WEST SUSSEX COUNTY COUNCIL CONSULTATION

TO:	Arun District Council FAO: Ms M Tomalova
FROM:	WSSC - Highways Authority
DATE:	4 August 2021
LOCATION:	Land adj to 1 Hook Lane Westergate PO20 3QL
SUBJECT:	AL/83/21/PL Demolition of existing storage building & garage, replace with 1 No. 3 bed dwelling, including new access to existing dwelling. This application is in CIL Zone 2 and is CIL liable as new dwelling.
DATE OF SITE VISIT:	n/a
RECOMMENDATION:	Advice
S106 CONTRIBUTION TOTAL:	n/a

SCALE: AS SHOWN
ORIGINAL SIZE: A1
DRAWING NUMBER: Idc-3354-01-PL

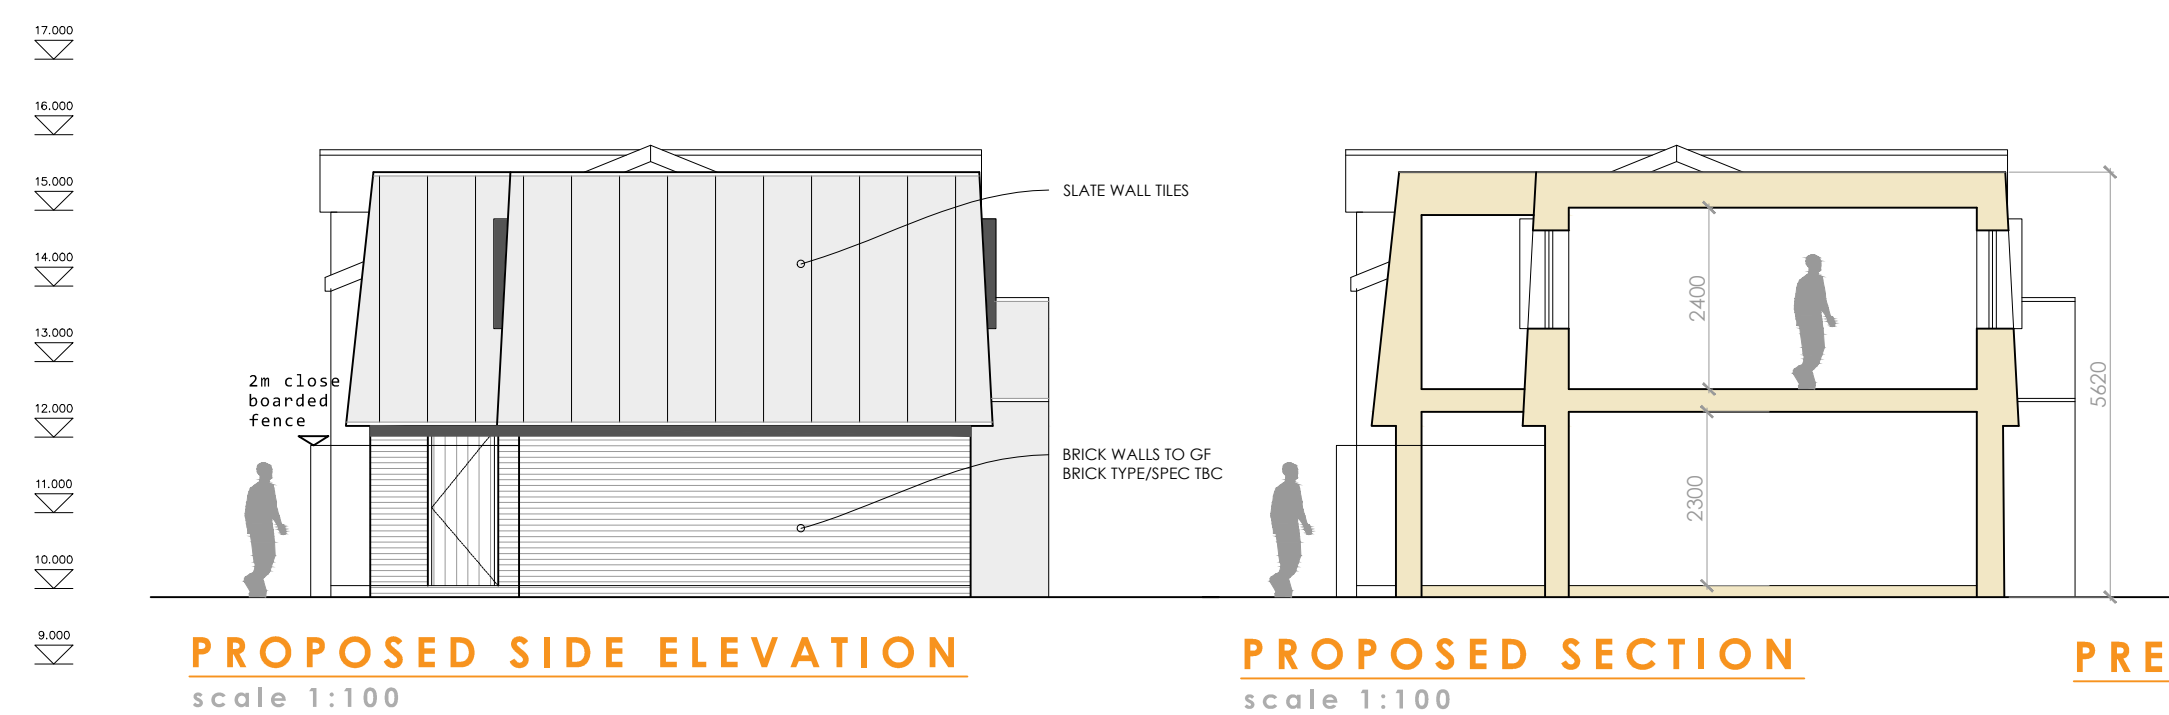
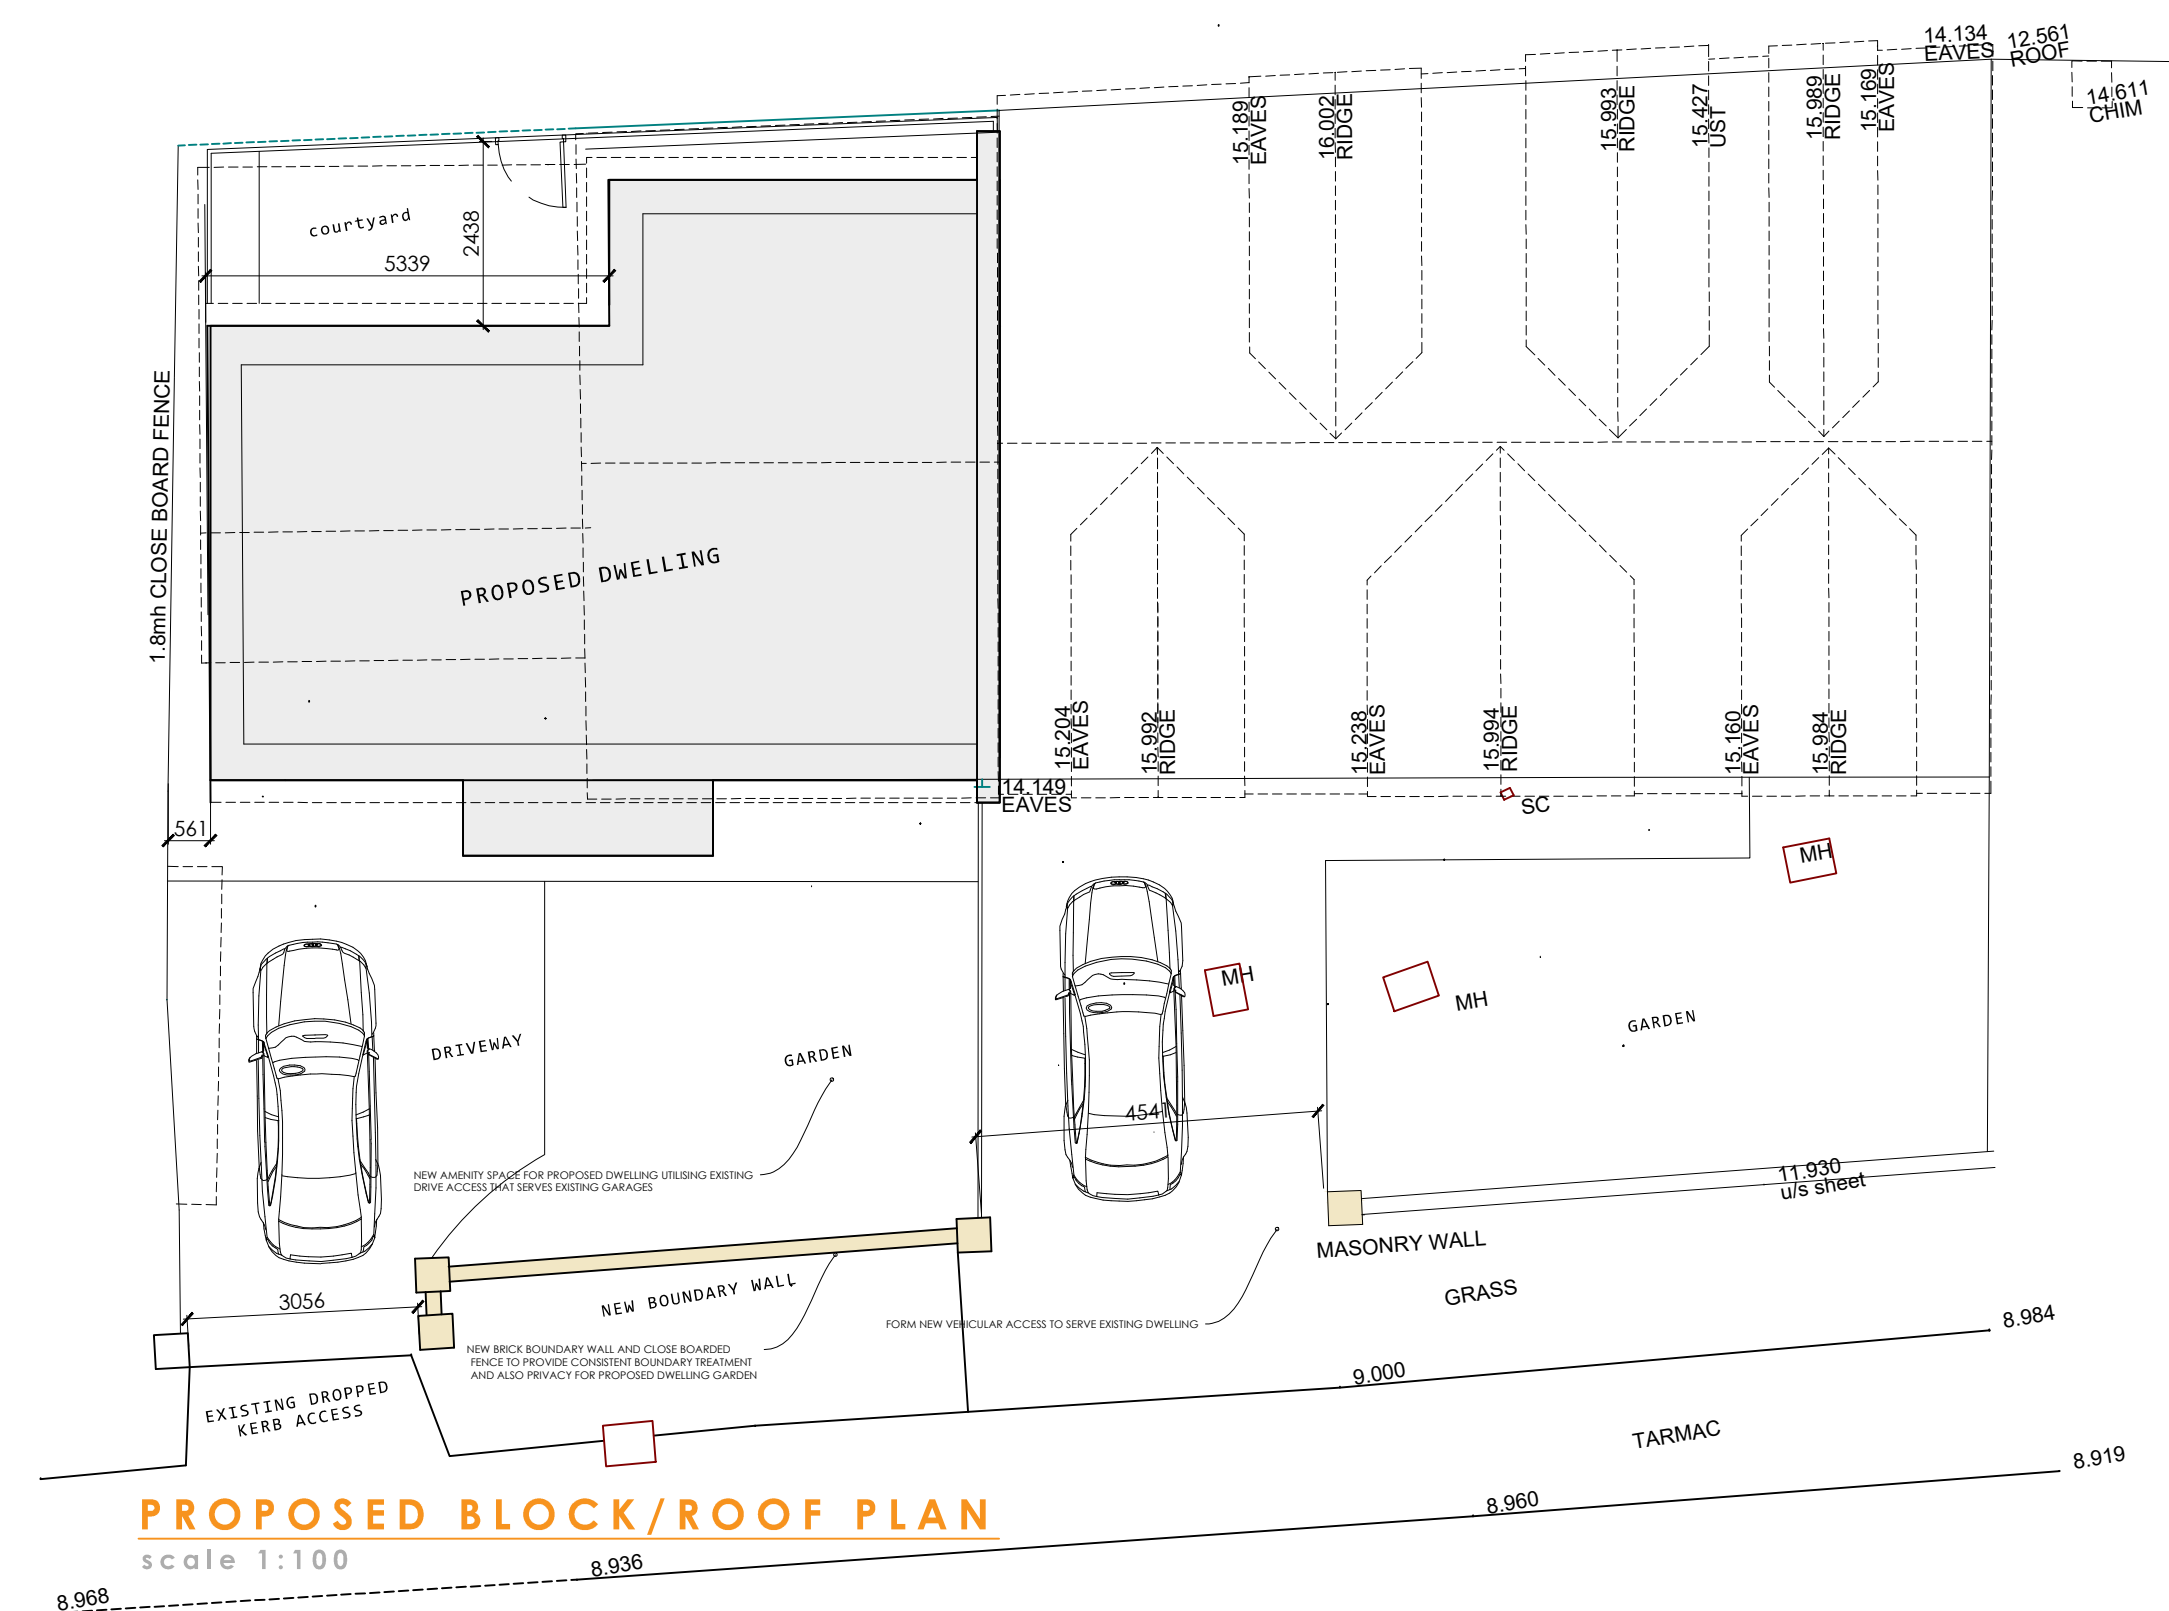
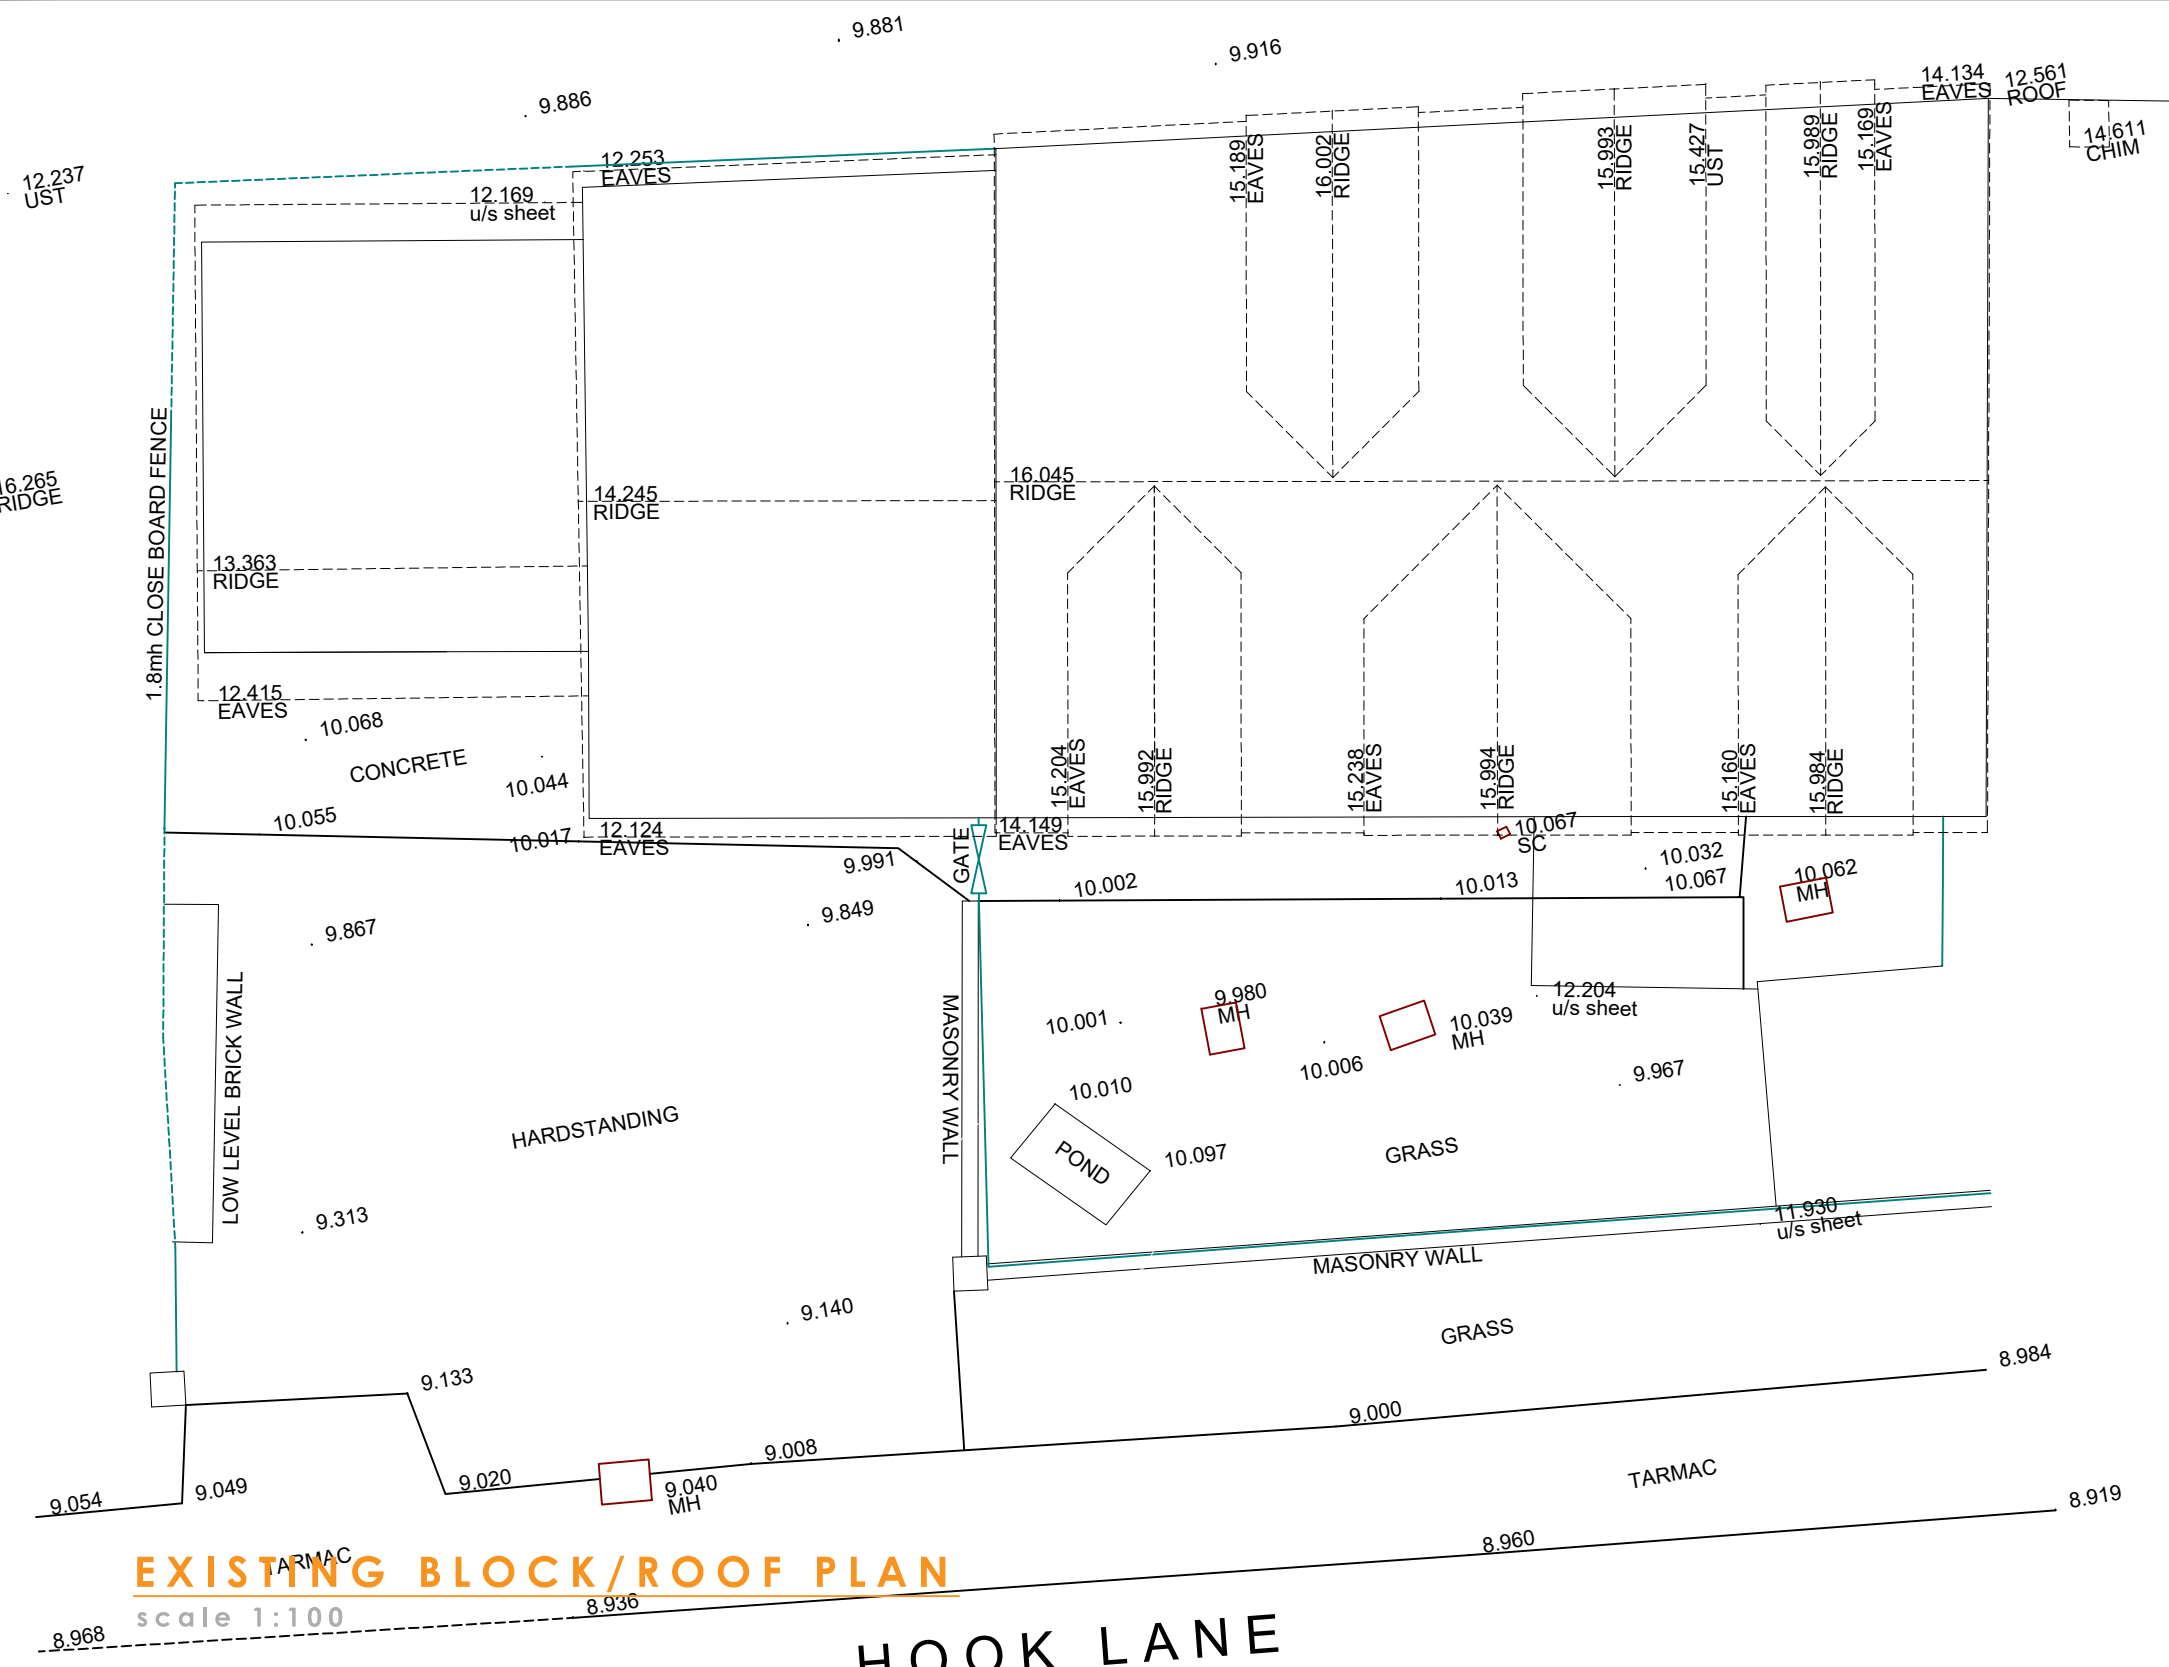
Access to the proposed dwelling will be provided via an existing dropped crossing. Given this dropped crossing was already serving a garage provision it would be not anticipated that the proposed will result in the intensification of use of the access point.

A single parking space will be provided for the new dwelling.

Using the Adopted Arun Supplementary Planning Documents (Parking), it would be anticipated that a dwelling of this size in this location would attract the demand for 2 car parking spaces. As 1 space is proposed it is anticipated that the proposal will result in

some degree of overspill parking onto the public highway. However, any overspill parking will have to park safely in accordance with any existing traffic regulation orders. As such it is extremely difficult to substantiate that this in itself will result in an unacceptable highway safety concern. The Local Planning Authority may wish to consider the amenity implications.

A new dropped crossing is proposed to provide replacement parking for the adjacent dwelling. The applicant has demonstrated that a 2.4m x 43m visibility splay can be achieved using land wholly contained within the extent of the highway boundary or that under control of the applicant. Works on the public highway for this new crossover must be implemented under licence to a specification obtained from WSCC Highways.

This will take the form of 1 hardstanding space. While bedroom number details of this existing dwelling have not been provided it would be anticipated that the existing dwelling would create the demand for 2 or 3 parking spaces. This quantum of demand could have been accommodated by the existing provision which will be lost as a result of this proposal. As such it is anticipated that the proposal may result in some degree of overspill parking onto the public highway. However, any overspill parking will have to park safely in accordance with any existing traffic regulation orders. As such it is extremely difficult to substantiate that this in itself will result in an unacceptable highway safety concern. The Local Planning Authority may wish to consider the amenity implications.

No part of the development shall be first occupied until such time as the vehicular access serving Athwal Cottage has been constructed in accordance with the details shown on the drawing titled Proposed Block Plan and numbered dc-3354-02-PL

No part of the development shall be first occupied until visibility splays of 2.4 x 43 metres have been provided at the proposed site vehicular access onto Hook Lane in accordance with the approved planning drawings. Once provided the splays shall thereafter be maintained and kept free of all obstructions over a height of 0.6 metre above adjoining carriageway level or as otherwise agreed.

No part of the development shall be first occupied until the car parking has been constructed in accordance with the approved site plan. These spaces shall thereafter be retained at all times for their designated purpose.
